From: Ian Brewster
Sent: 16 June 2011 17:03
To: Janice Chapman
Subject: FP/91/11/T 41 Downview Road Felpham

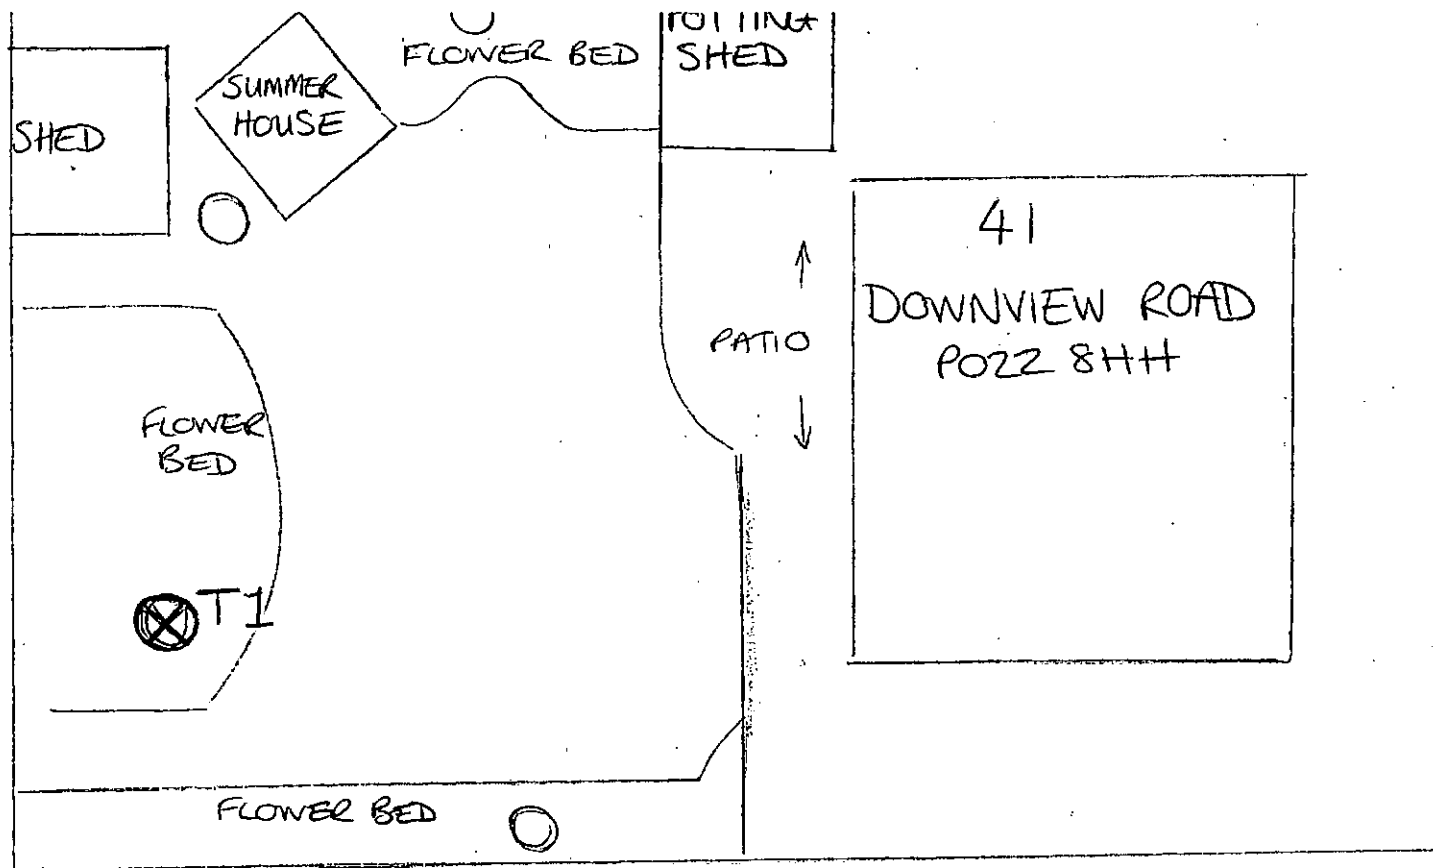
the Sycamore tree is barely visible from the highway. However dead branch ends could be seen and the recommendation by the tree consultant (Rob Dorey) would appear acceptable and is recommended.
